CITY OF ALBUQUERQUE

Site: Legacy NAA Apartments: Alameda and San Pedro

Re: Drainage Ordinance (14-5-2-1) Violations for Erosion and Sediment Control

### Stabilized Construction Entrance

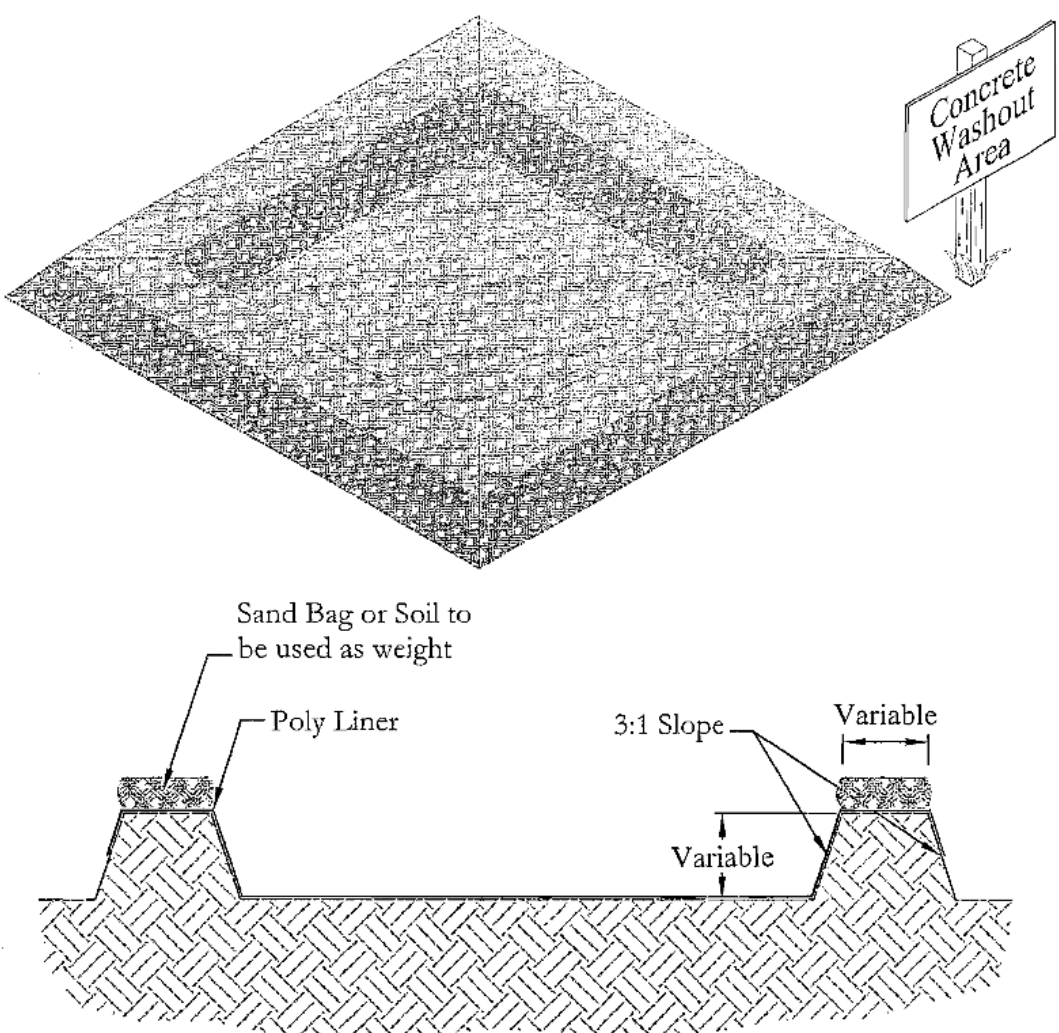
1. Three exit locations from the site without stabilized construction entrances (track-out pads).
2. Sediment in San Pedro Blvd and Oakland Ave.
3. Silt fence not buried.

No track-out pad onto San Pedro Blvd. Sediment in street.

No track-out pad onto Oakland Ave. Sediment in street.

Additional entrance onto Oakland Ave. without a track-out pad. Sediment in street.

1. Install stabilized construction entrances (track-out pads) at all locations where vehicles are leaving the site per the approved Erosion and Sediment Control plan details. Currently workers are exiting the site in three locations. The laydown yard/parking lot west of the buildings is part of the site.
2. Remove sediment from San Pedro Blvd and Oakland Ave. along the frontage of the project.
3. Maintain or reinstall silt fence per the approved Erosion and Sediment Control plan details.
